Fire Marshal Division

March 11, 2021

Re: Carolina Charter Academy Addition
8529 Highway 55
Angier, NC 27501

Application Number FMFW2103-0001

**FIRST FLOOR PLAN - COMPOSITE**  
 1/16" = 1'-0"

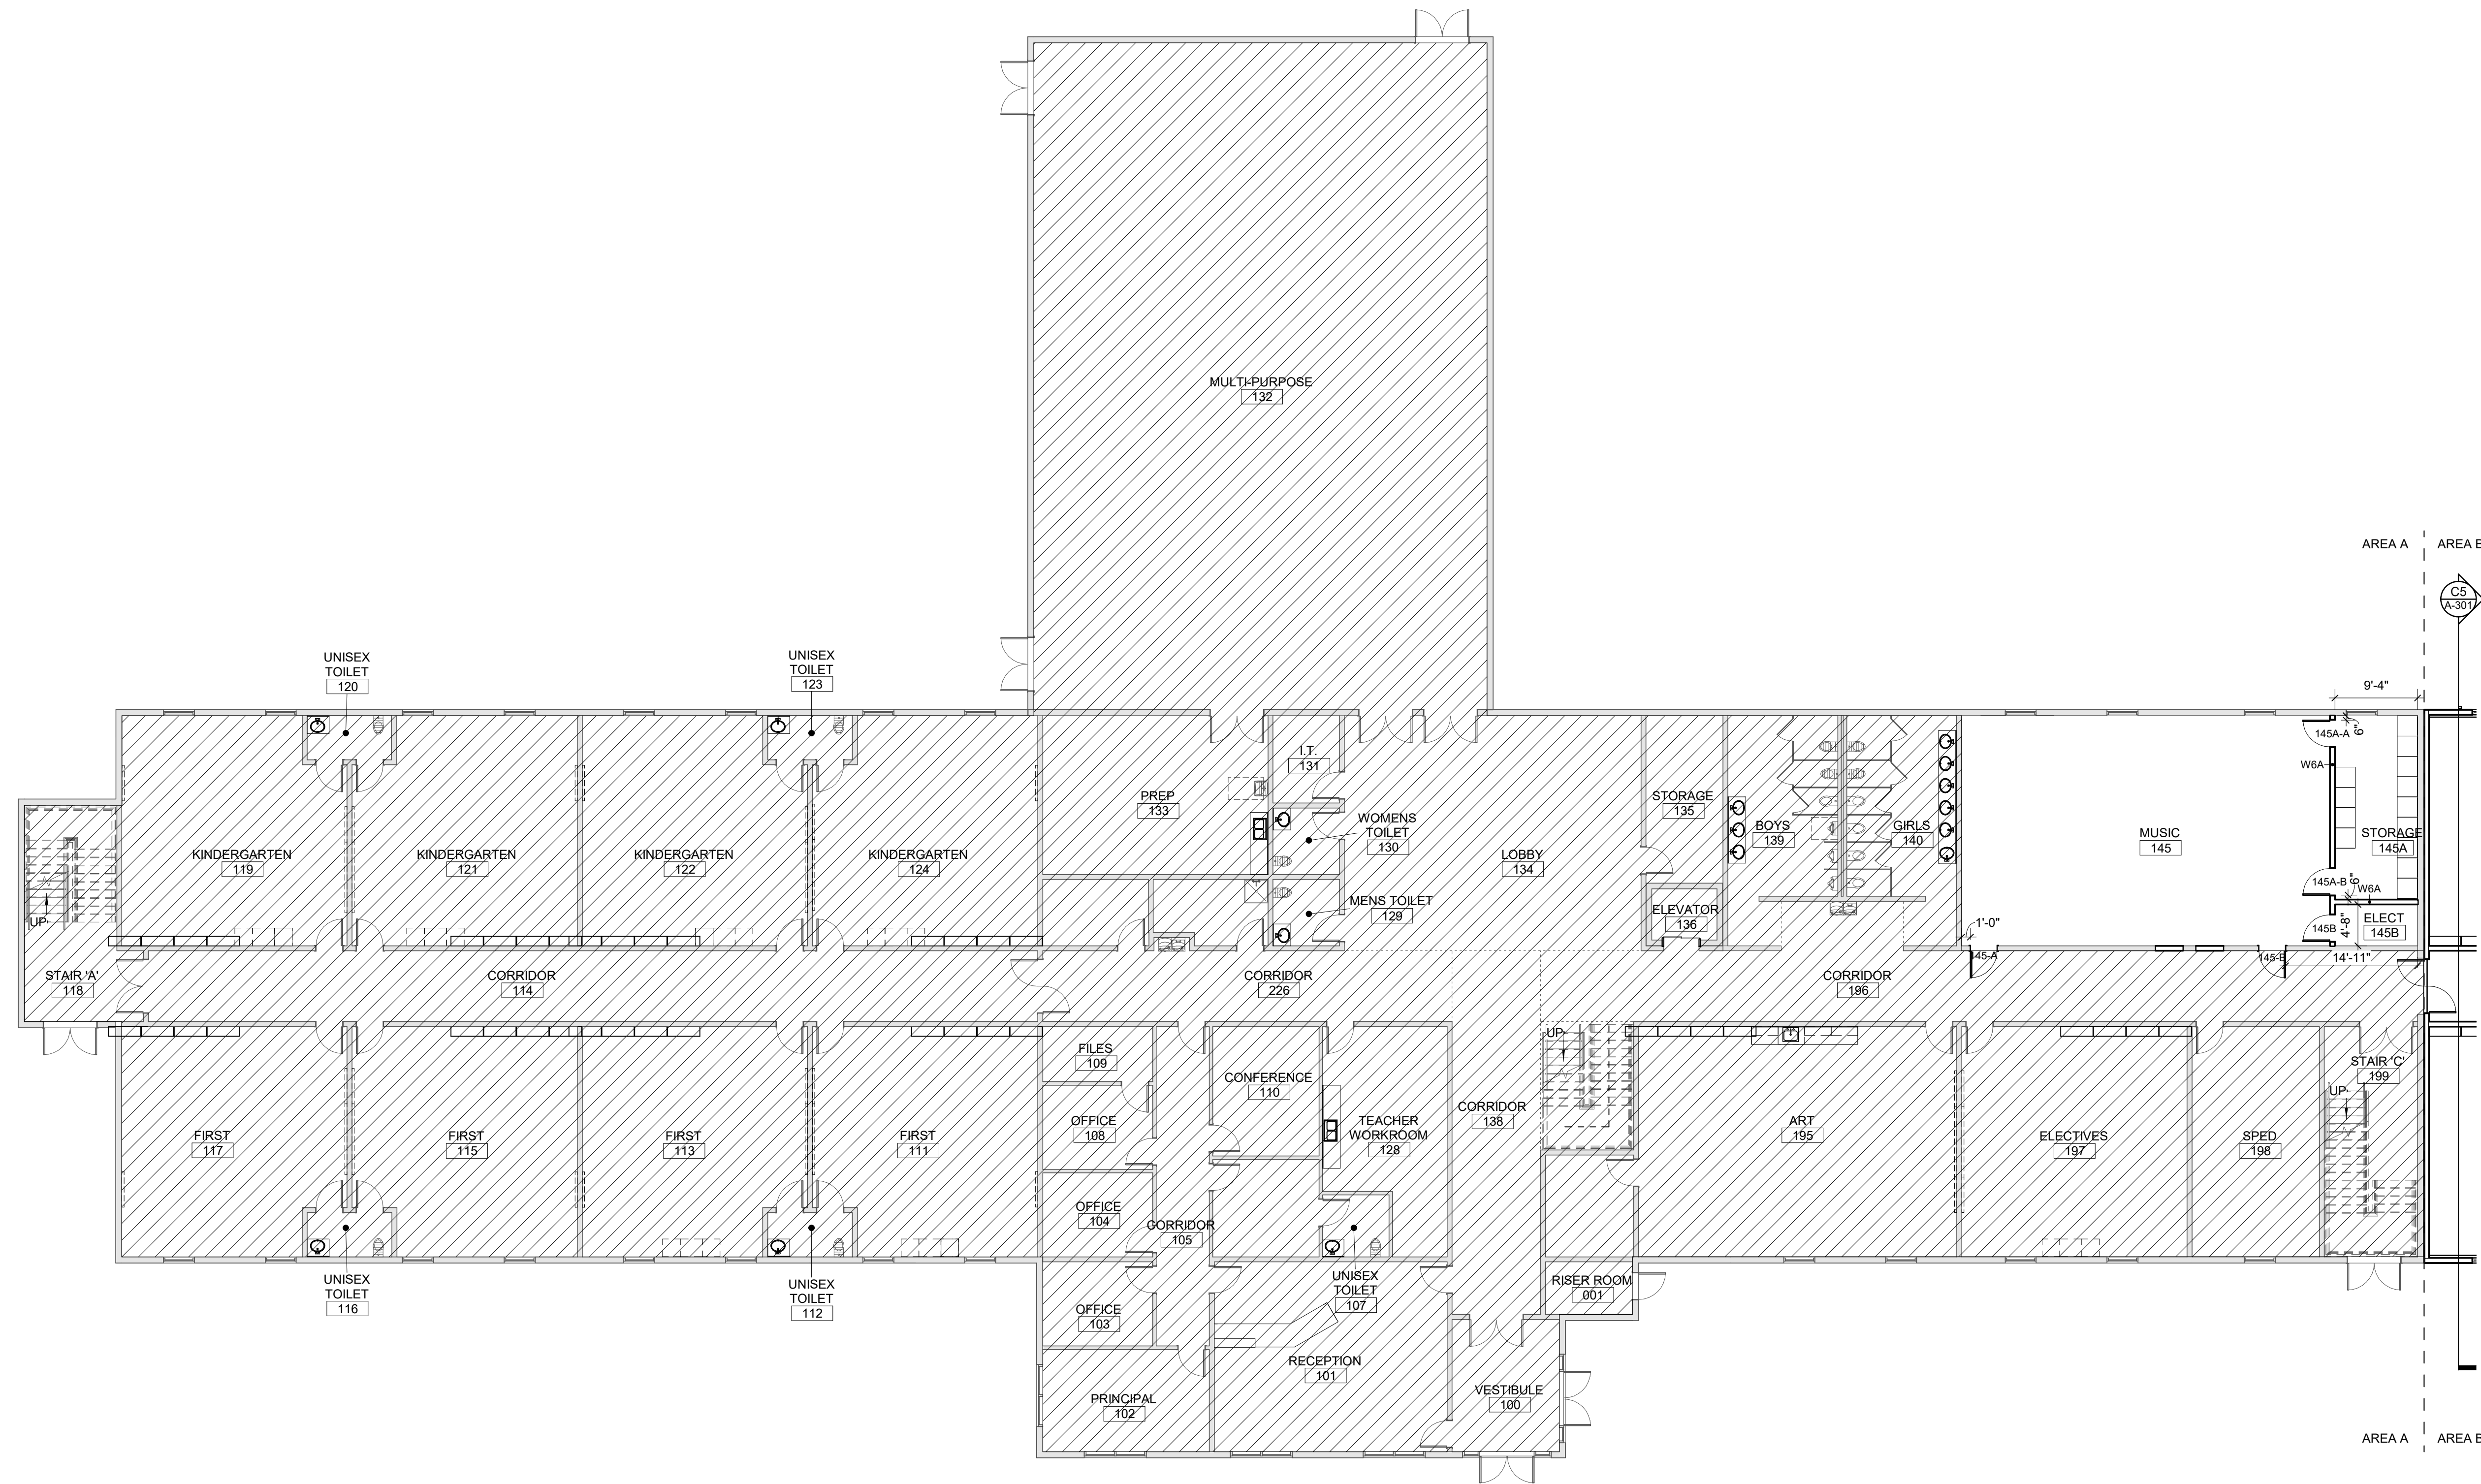
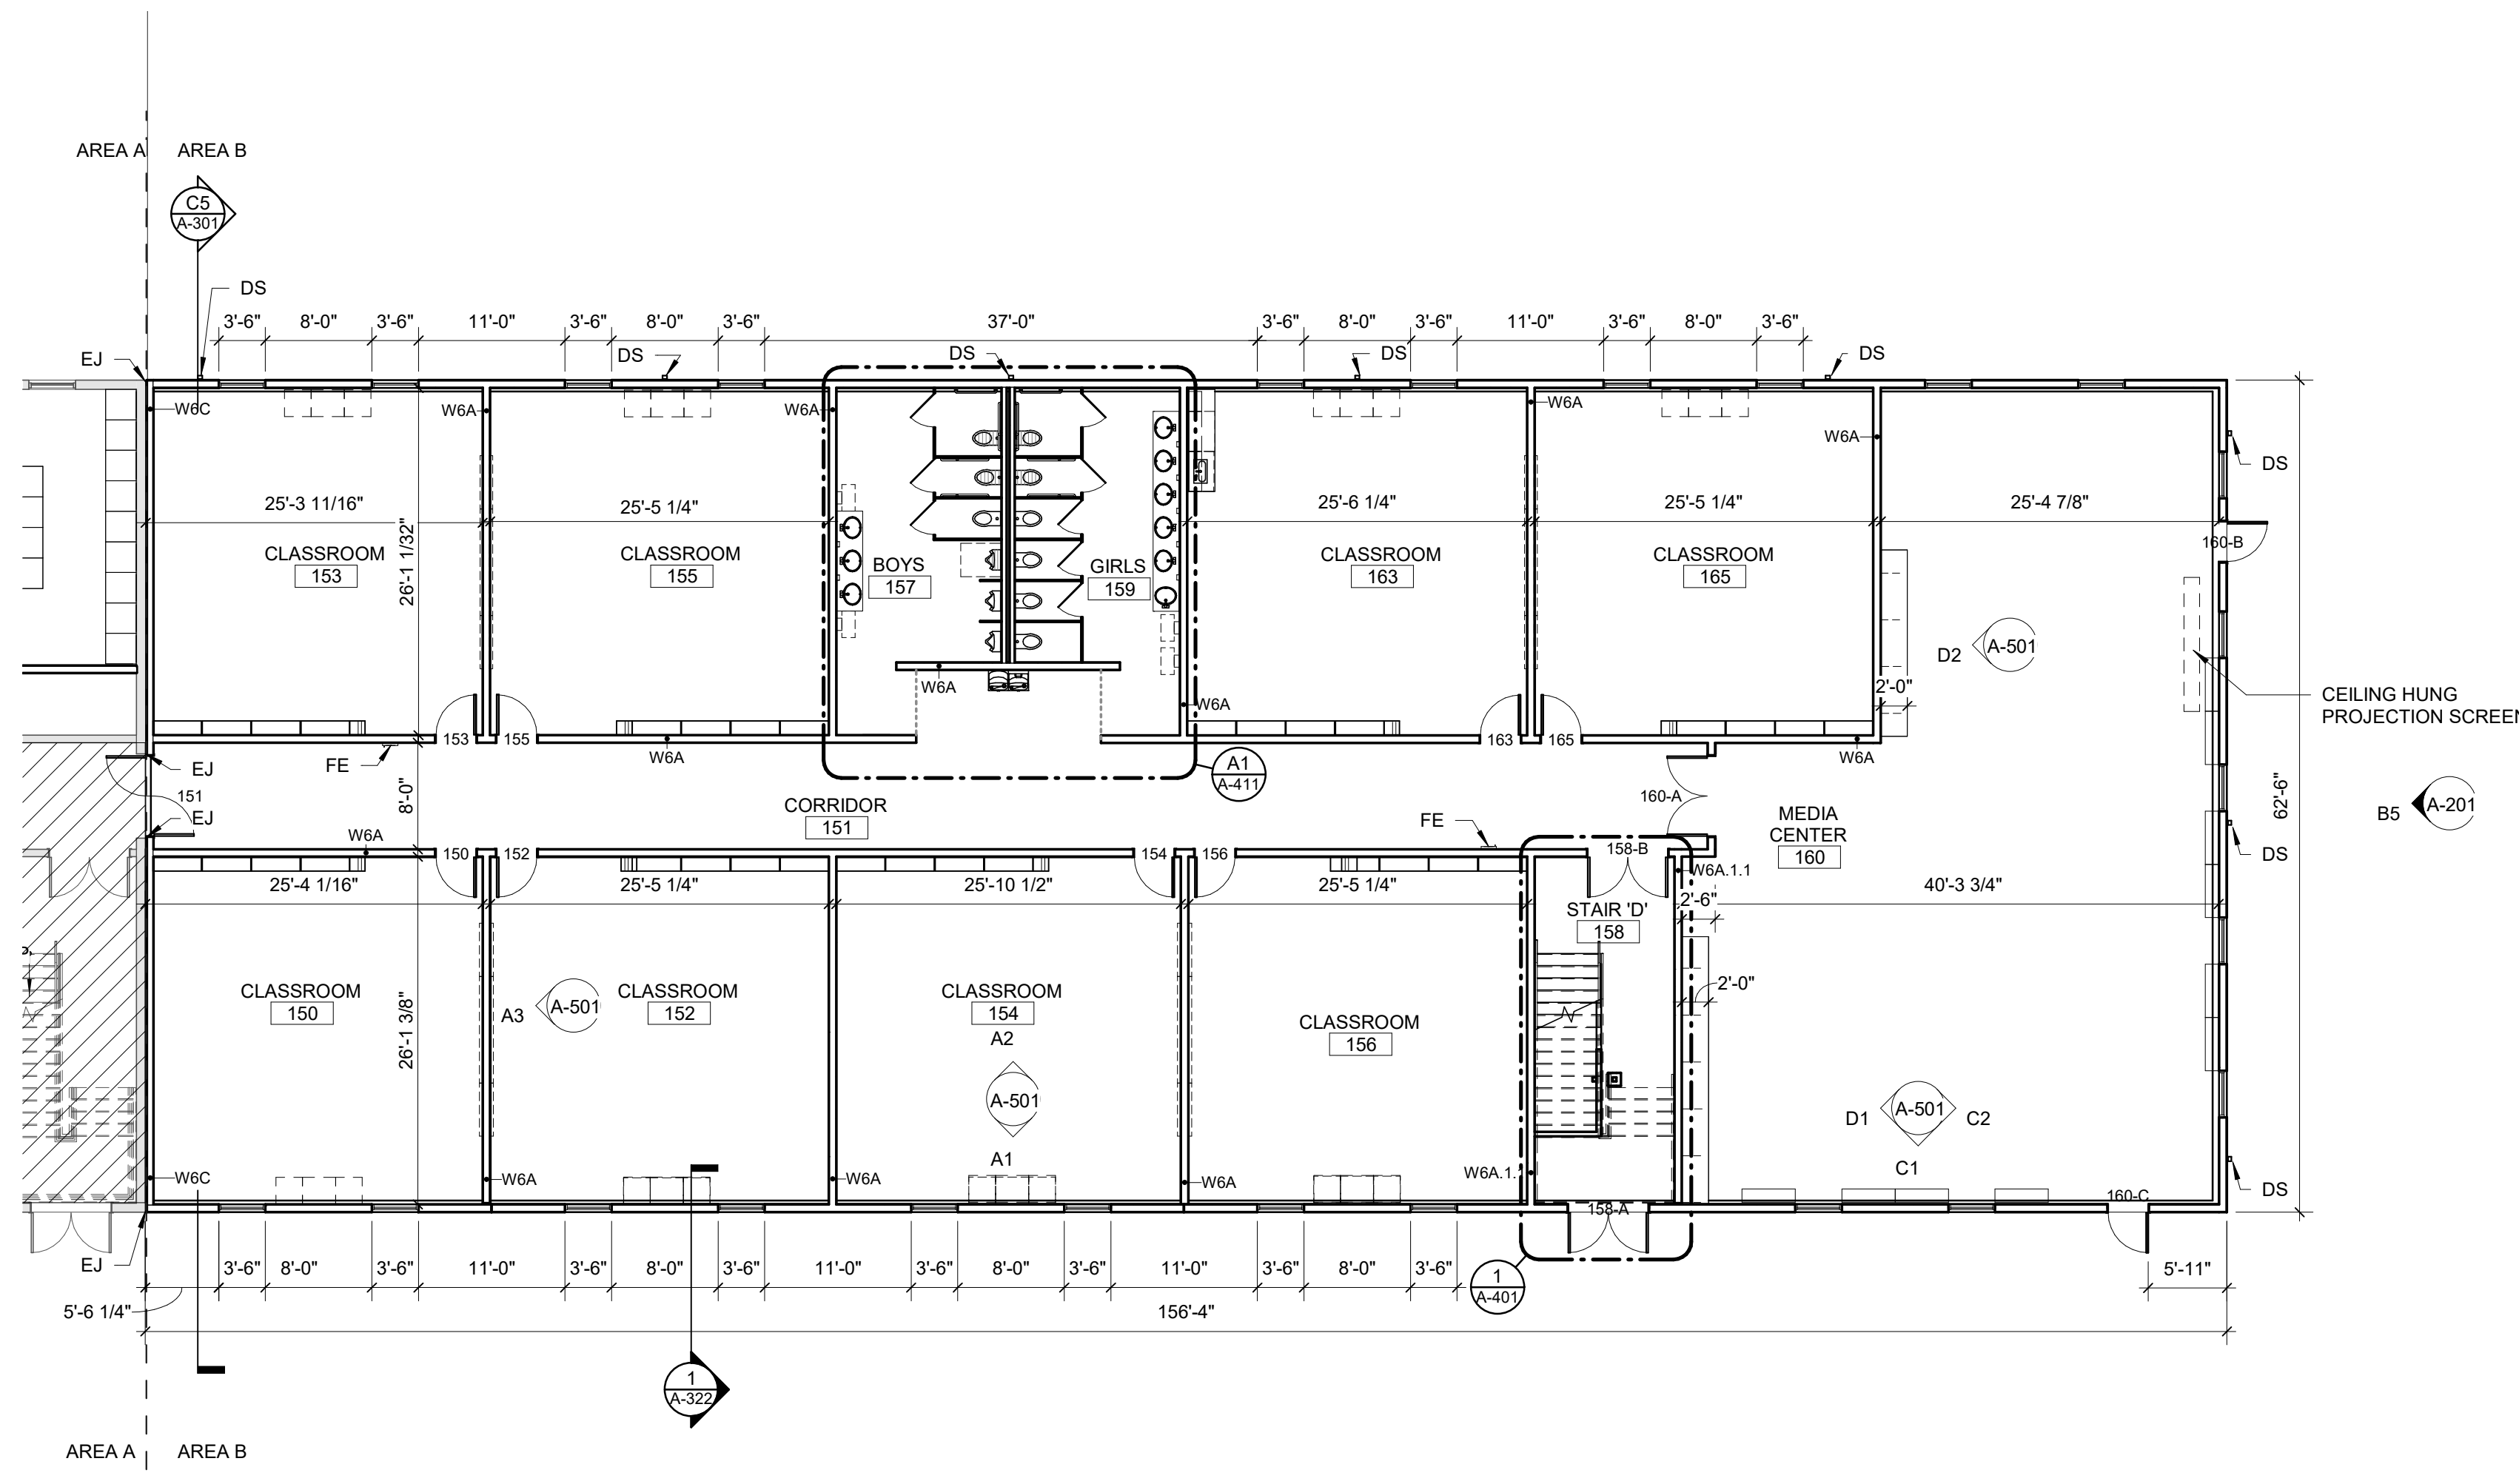
- **Egress Convergence**
 - Where means of egress from floors above and below converge at an immediate level, the capacity of the means of egress from the point of convergence shall not be less than the sum of the two floors. First and second floor stairways do not meet this requirement.

- **Enclosures required**
 - Interior exit stairways shall be enclosed with fire barriers constructed in accordance with Section 707 of the International Building Code. Exit enclosures shall lead directly to the exterior of the building. Stairway B does not meet this requirement.
